**ADC Planning Consultation
Response from the Historic Buildings Adviser**

Application Number	Y/99/13
Address	Land to the north and east of St Mary's Church, Yapton
Description	Outline application for up to 250 dwellings.
Case Officer	Cian Cronin
Site Visit	5 February 2014

K Langmead
St Mary's Park North End Road Yapton
Proposed Indicative Layout, Strategic Landscape & Open Space Proposals
SCALE 1/2000 @ A1
Drawing number 102C

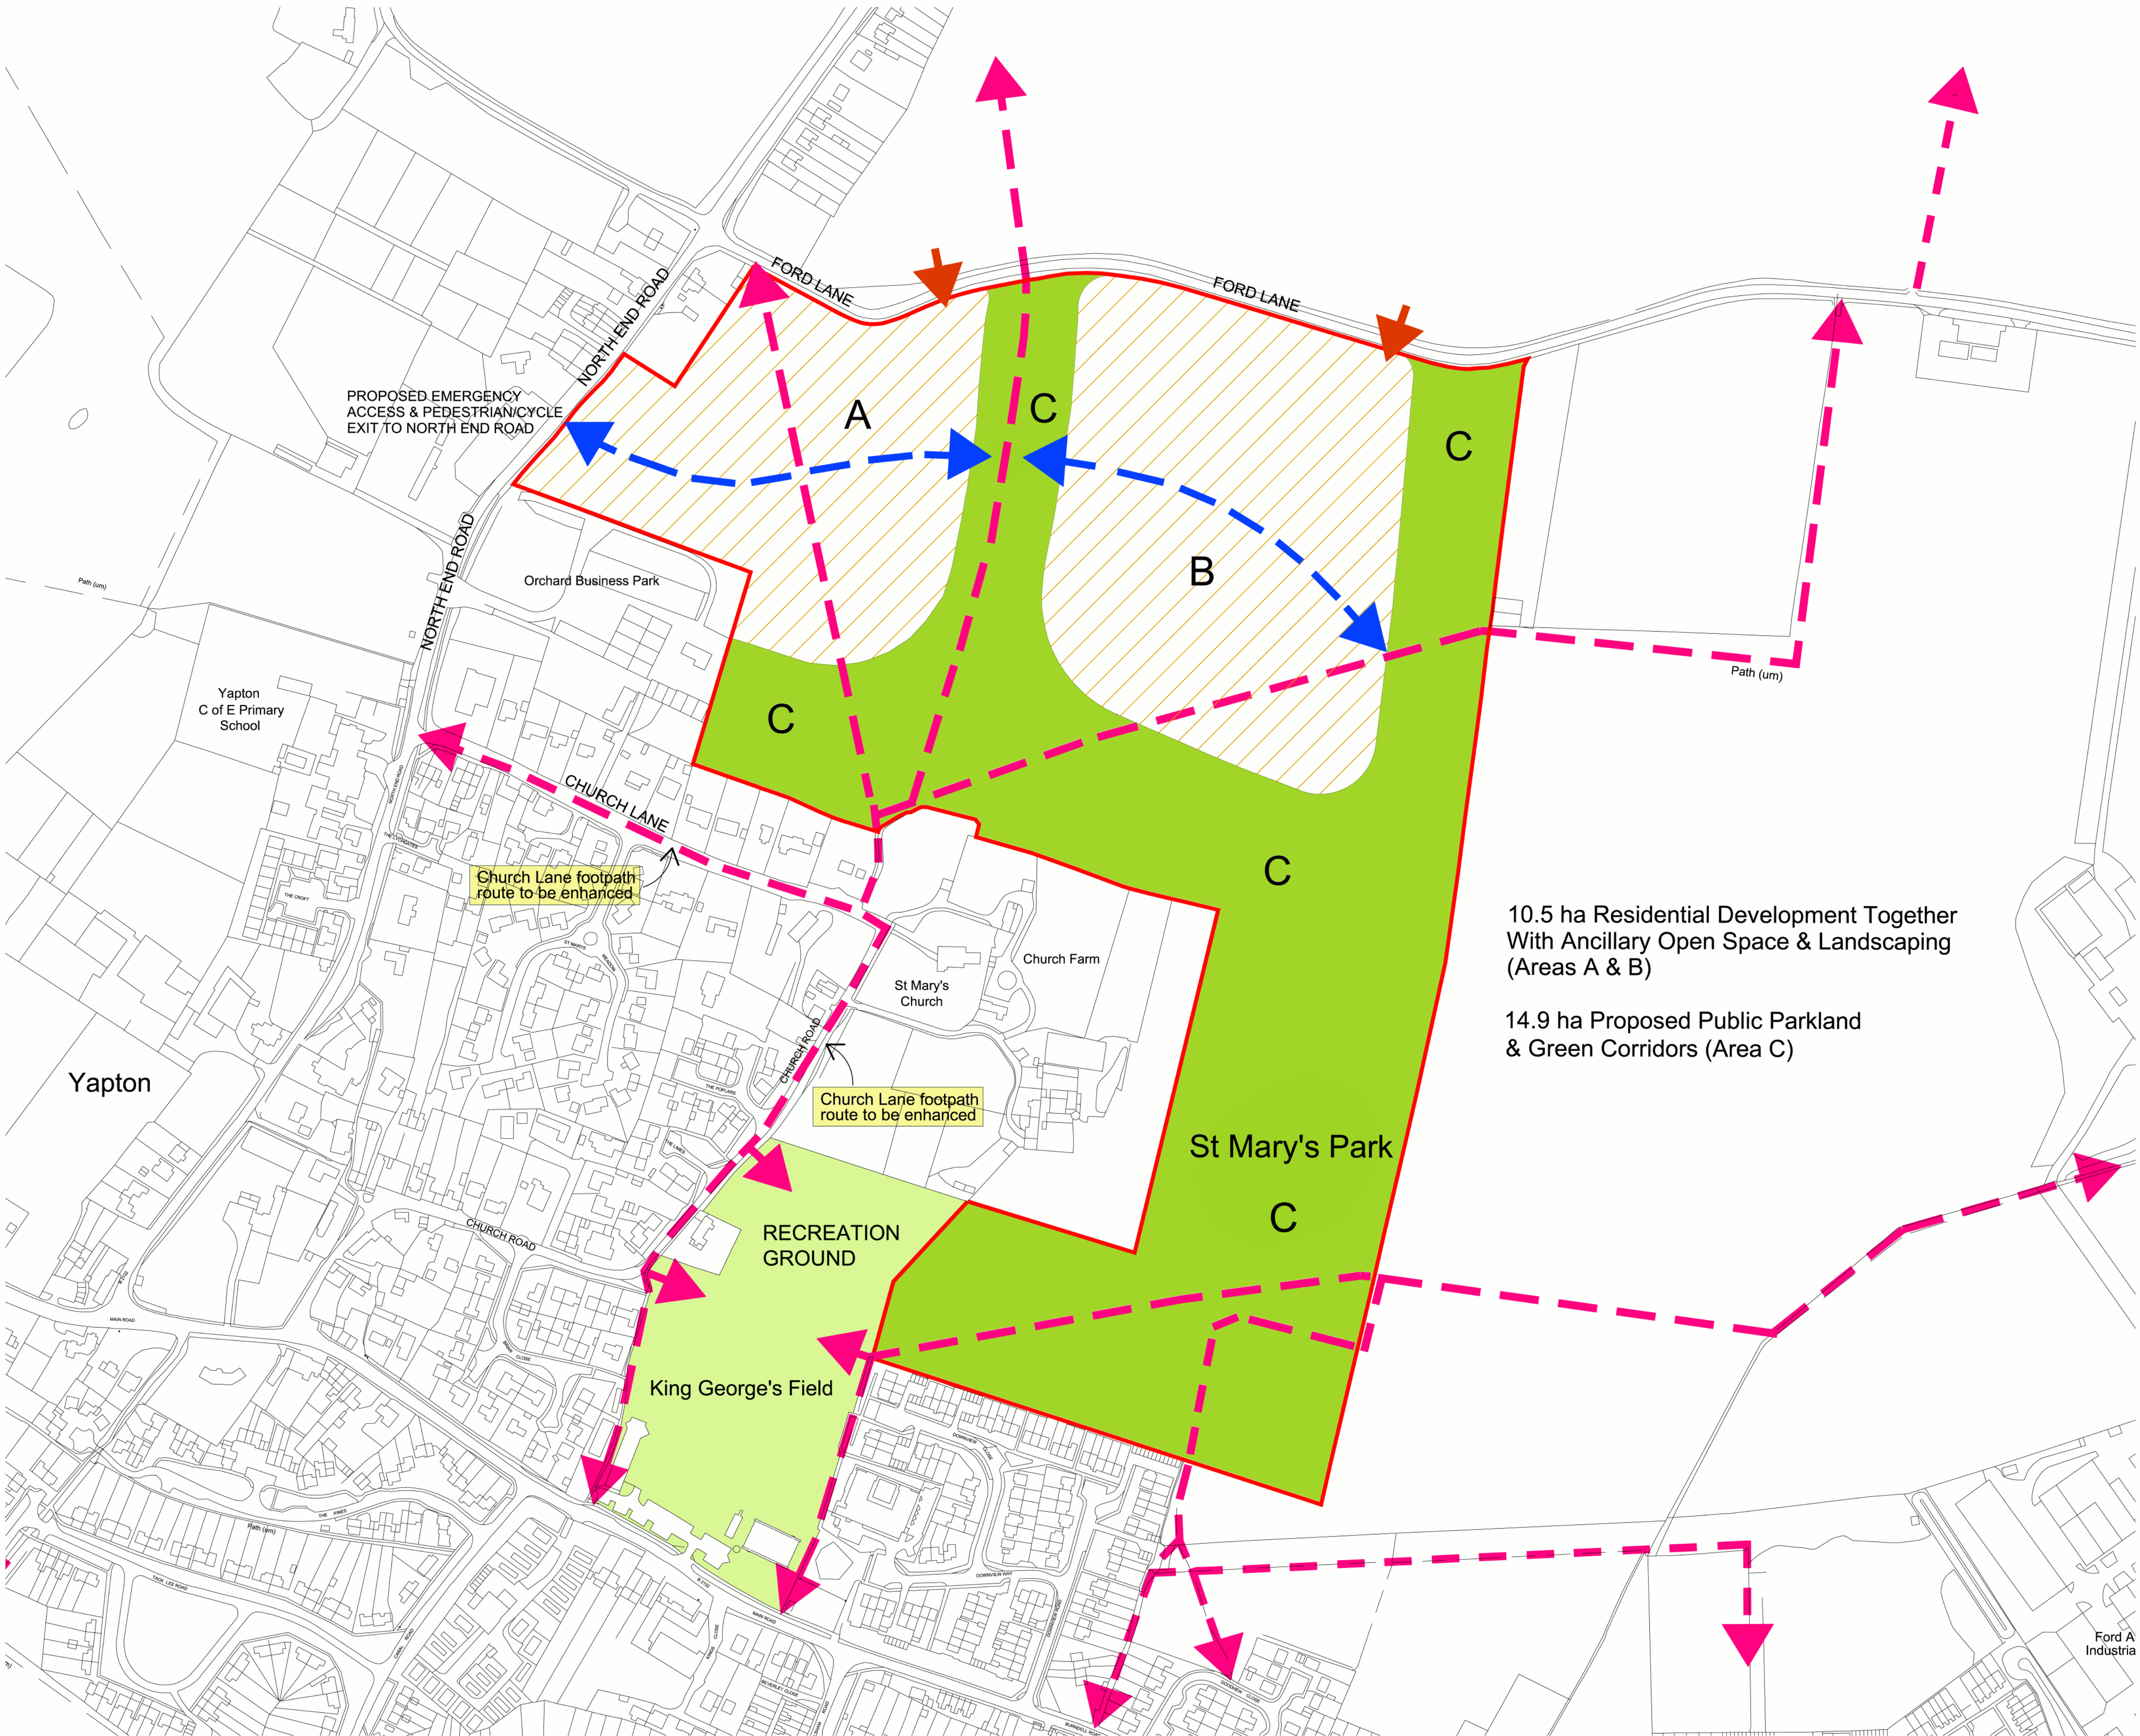
something that would be totally lost if surrounded by development. The idea that to 'cocoon and surround the church' would somehow represent an enhancement of the heritage asset is bemusing to say the least. Similarly, the suggestion that the application will provide public space to expose a 'largely hidden view', of the Church is equally baffling and misguided given that public footpaths already provide this aspect across the totality of the site.

The proposed siting and scope of the scheme will therefore not only block long views of the downs and other heritage assets, but will also impact the immediate historical and agricultural context of the village, raising other issues of setting which similarly have not been addressed.

The proposed gap between the historic village and the new development is symptomatic of this, its arbitrariness is symbolic at best, but ultimately meaningless and lacking any rigour in its assessment. As a consequence it also neglects more holistic impacts which could also undermine the setting and rural context of this part of the Conservation Area. English Heritage guidance on setting clearly outlines a number of physical features and factors which inform the experience of an asset. In this instance these might include:
